# Gatwick Airport Northern Runway Project

Response to the Examining Authority's Written Questions  
(ExQ2) – Land Use and Recreation

Application Document Ref: 10.56.9

Temporary NCR 21 Diversion

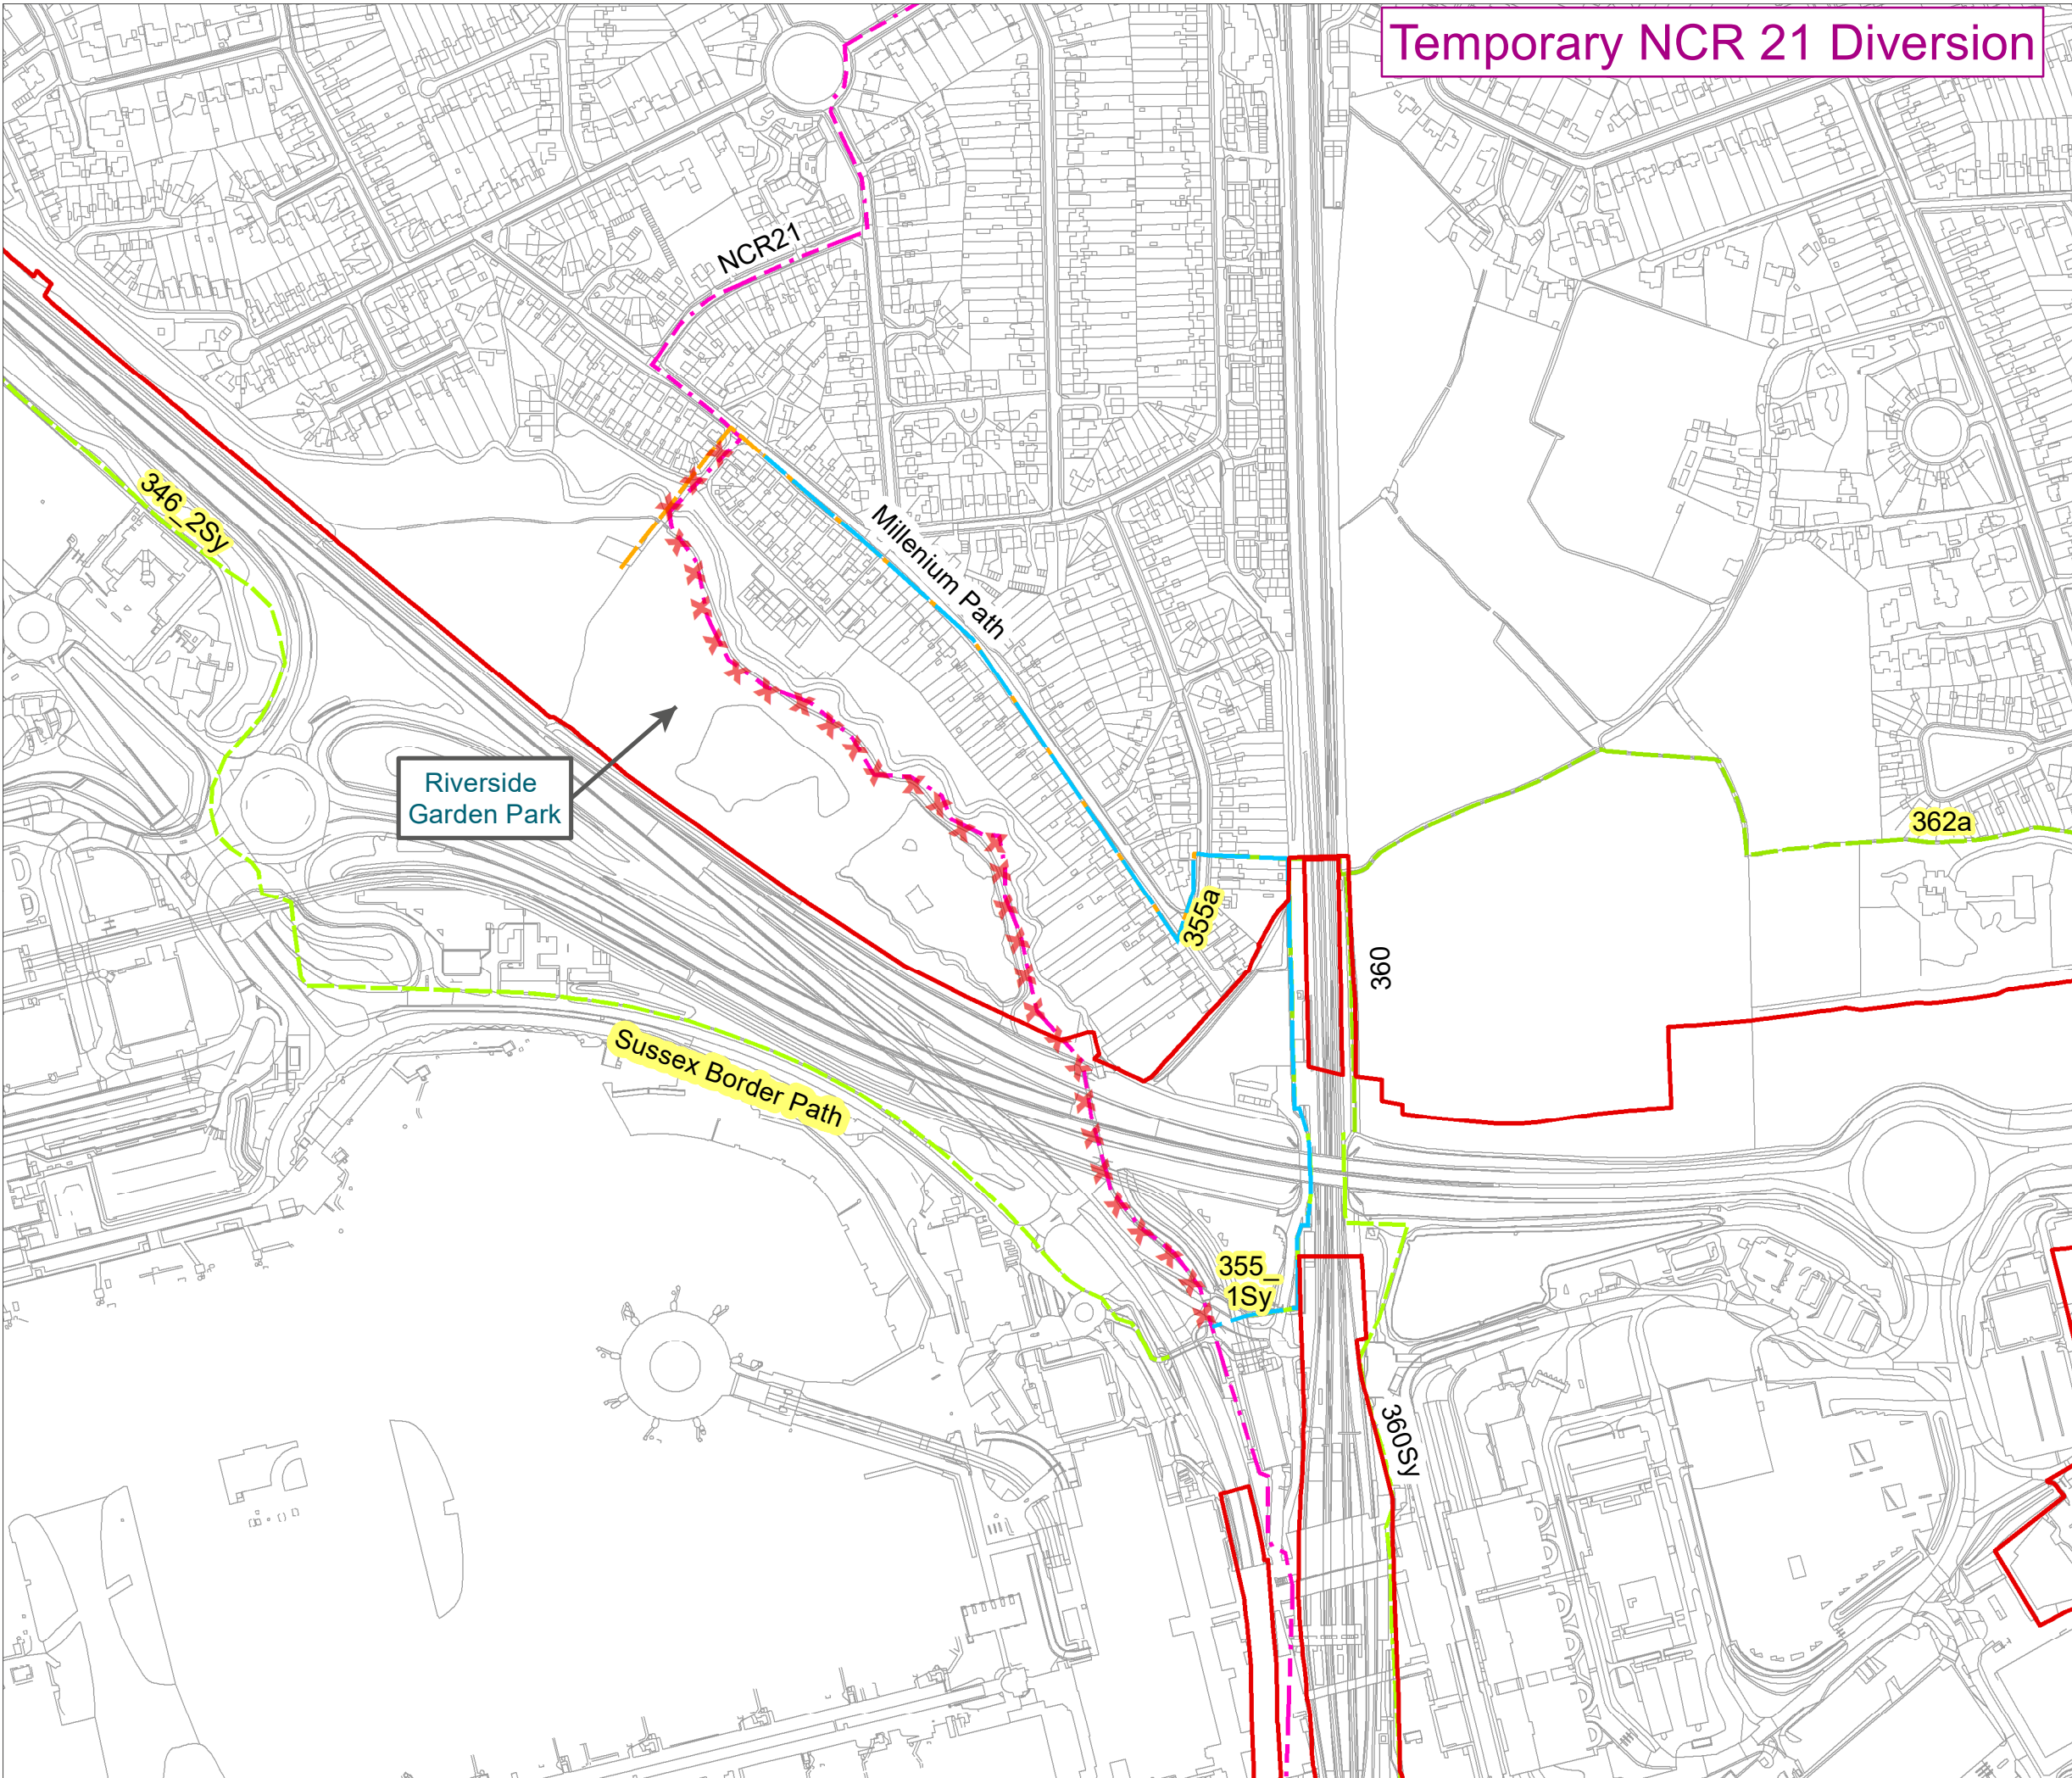
ExQ1 Question to: Question:		
LAND USE AND RECREATION		
LU.2.1	Applicant	<p><b>Public Rights of Way management and temporary diversions during construction</b></p> <p>Row AR-3 of the Mitigation Route Map [REP2-011] states that <i>“Improvements to National Cycle Route 21 from the western edge of Car Park B to the south of the airport will be considered”</i>.</p> <p>Please signpost to information regarding improvements which are being proposed/ considered.</p>
		<p>The improvements to National Cycle 21 in this specific area that are being considered are upgrades to the routing and installing additional signage. These improvements have been considered as enhancements within the application.</p> <p>Paragraph 2.2.5 of Appendix A to The <b>Applicant’s Response to Actions - ISH4 Surface Transport</b> [<a href="#">REP1-065</a>] states:</p> <p>“In addition to new and enhanced cycle parking the condition of NCR21 as it passes underneath South Terminal is the subject of a further improvement project as part of business as usual investment. Regular audits of facilities, including how well they are used will guide subsequent enhancement through the Northern Runway Project, funded through the Sustainable Transport Fund.”</p> <p>In addition, on line 17.1K of the <b>Applicant’s Response to Deadline 4 Submissions</b> [<a href="#">REP5-072</a>] additional detail was provided as follows:</p>

<p>"In the Crawley LCWIP 2021 there are two cycling routes identified that connect to/from Gatwick: - Route A: Gatwick Airport to town centre via NCR21, Manor Royal and Northgate. On this route Gatwick is investigating the delivery of improvements to NCR 21 at the southern end of Route Q / northern end of Route A to be delivered either as part of the Project or as a separate scheme. The envisaged improvements include improving wayfinding and the condition and alignment of NCR21 where the route passes beneath the railway station and South Terminal buildings, as recommended by the Crawley LCWIP. The widening of a short section of the path to the south of the railway station is also being investigated, near the crossing of Gatwick Stream, to remove a pinch point constraining active travel users (subject to acquiring rights over a parcel of Crown Land). The timeline for the delivery of these NCR21 works is to be confirmed at a later date."</p>

Temporary Diversion 346_2Sy

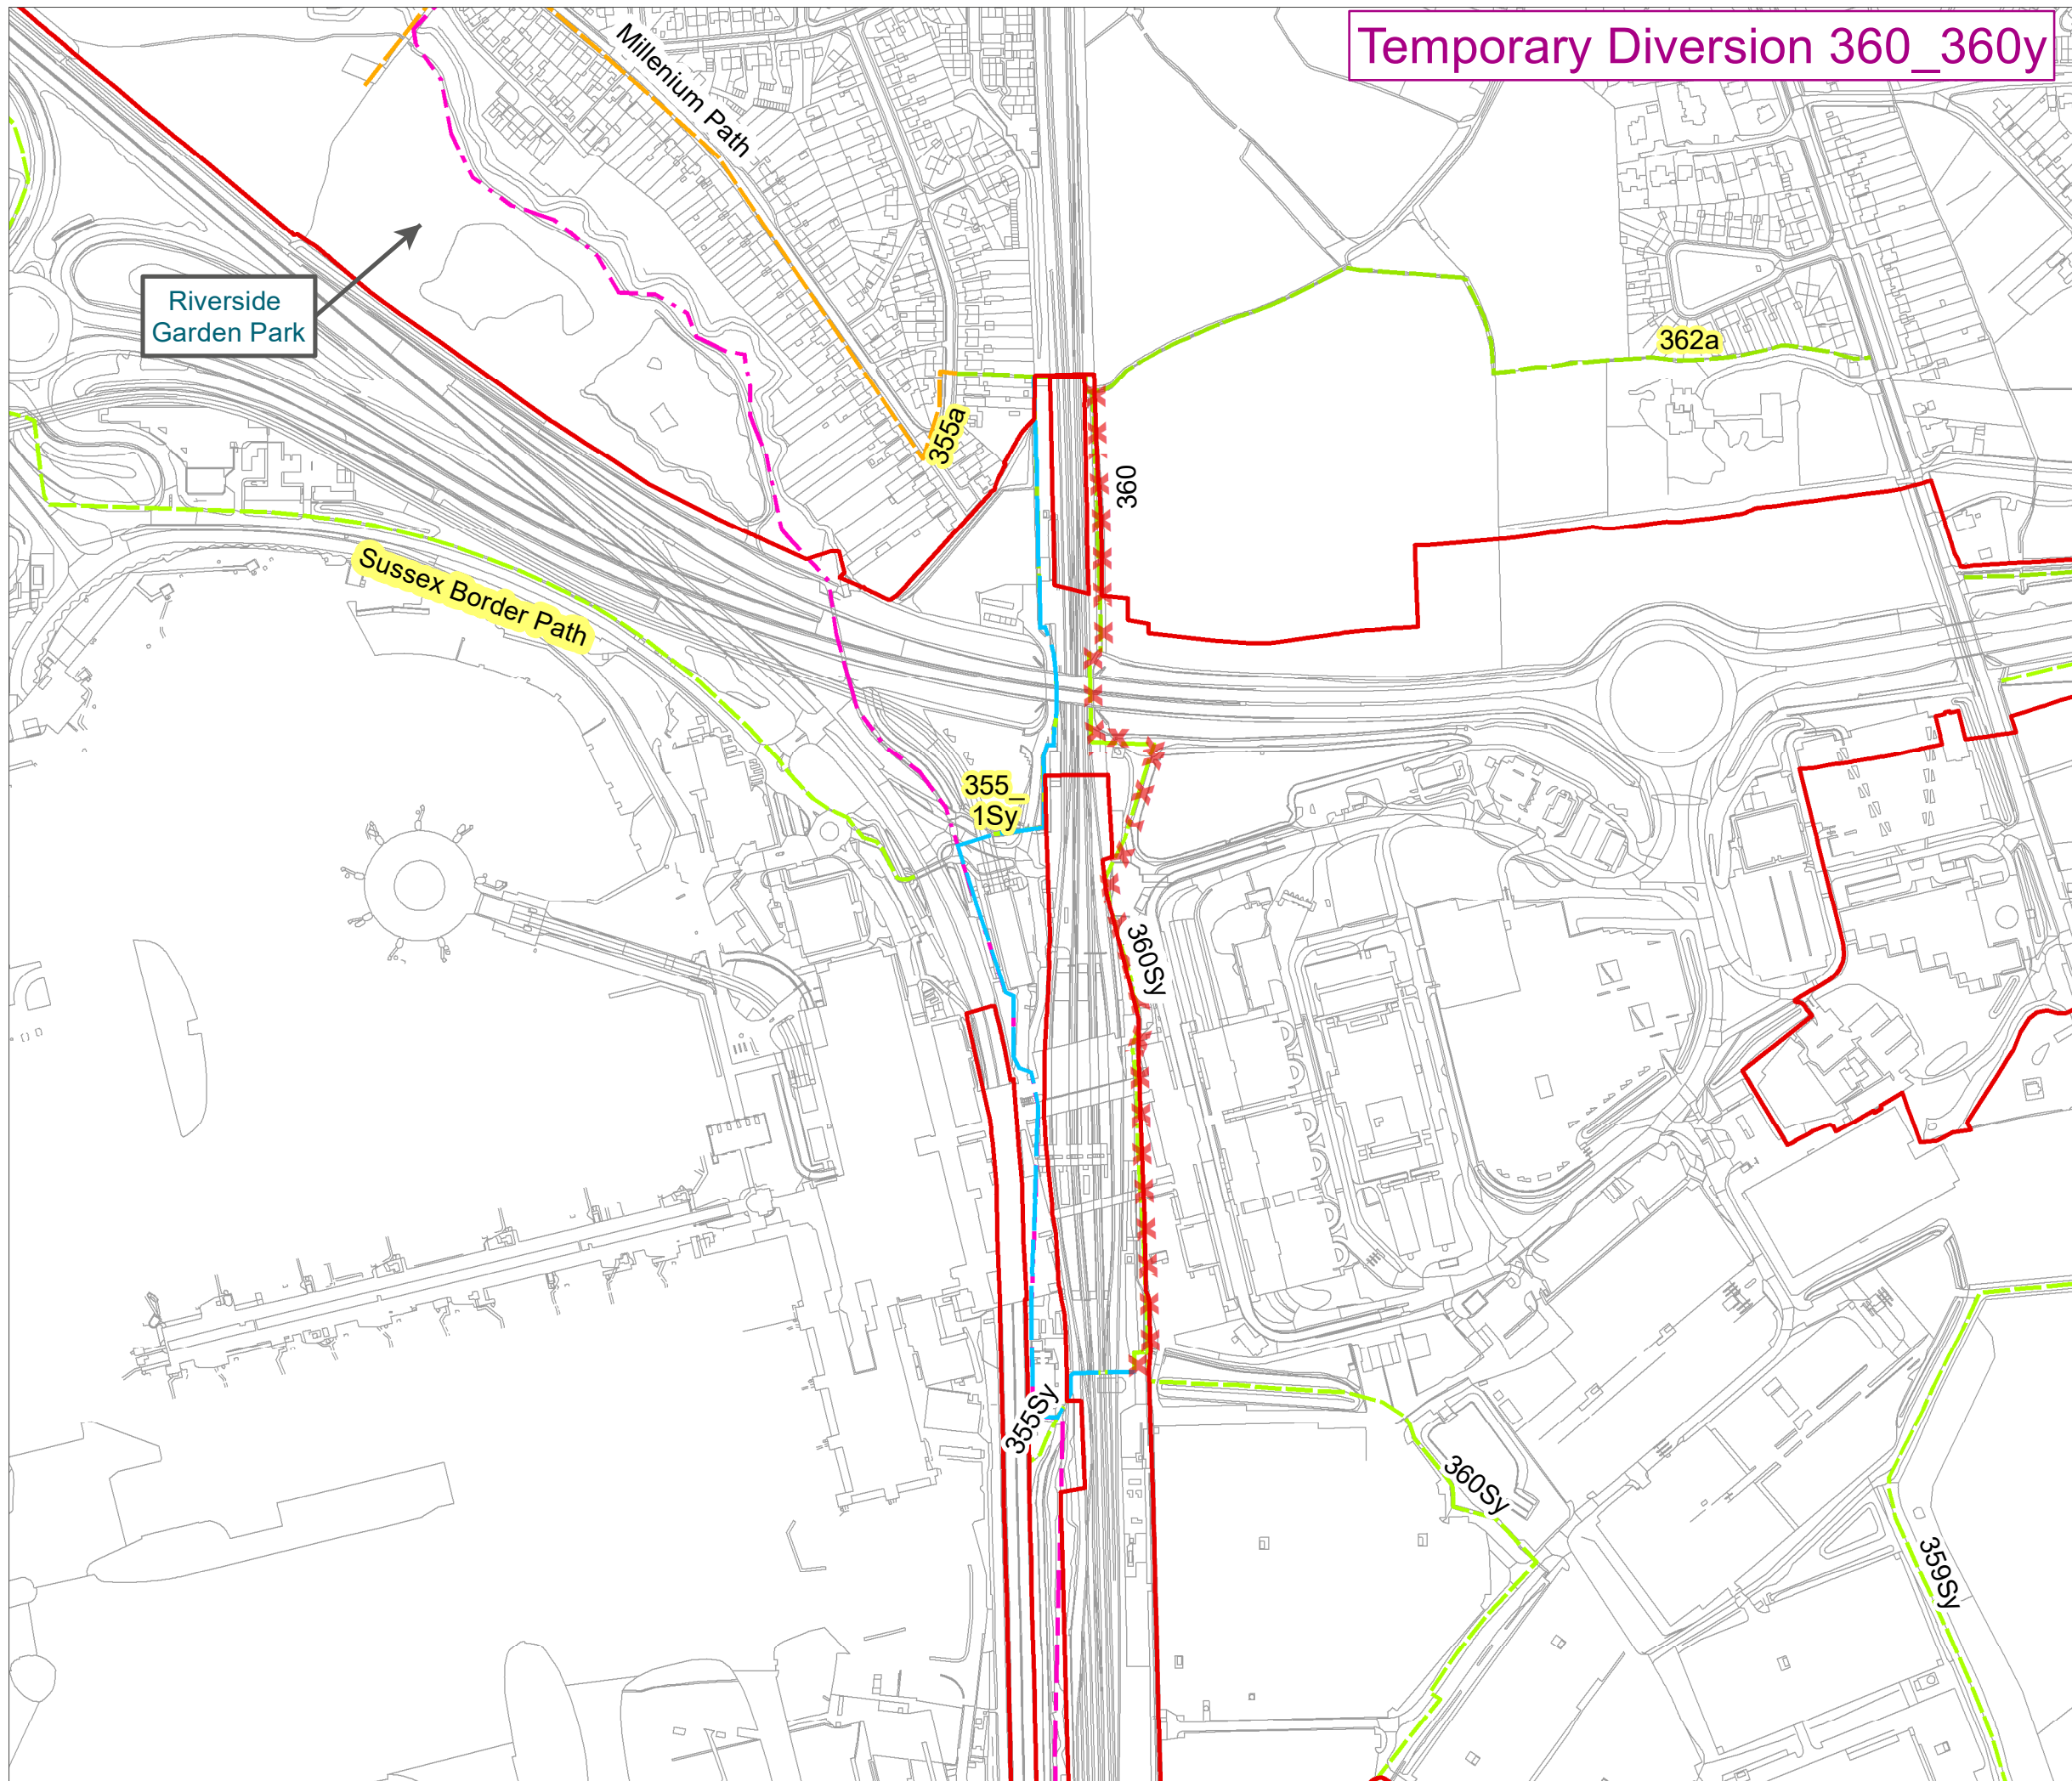
LU.2.2	Applicant	<p><b>Public Rights of Way Management Strategy</b></p> <p>In respect of Table 4.1.1 of the Public Rights of Way Management Strategy [REP2-009], please confirm how long West Sussex 346_2Sy is to be temporarily closed/ diverted?</p> <p>It is expected to be temporarily closed and diverted for approximately 3 years. The temporary diversion route would be implemented to the west and south of Car Park Y to rejoin the Sussex Border Path at North Terminal Roundabout and has been identified and assessed in <b>ES Chapter 19: Agricultural Land Use and Recreation [APP-044]</b> paragraph 19.9.30.</p> <p>The detail of the diversion route and the closure of the existing PROW will be set out in a PROW Implementation Plan which must be substantially in accordance with the Public Rights of Way Management Strategy and must be approved by the relevant highway authority under DCO Requirement 22.</p>
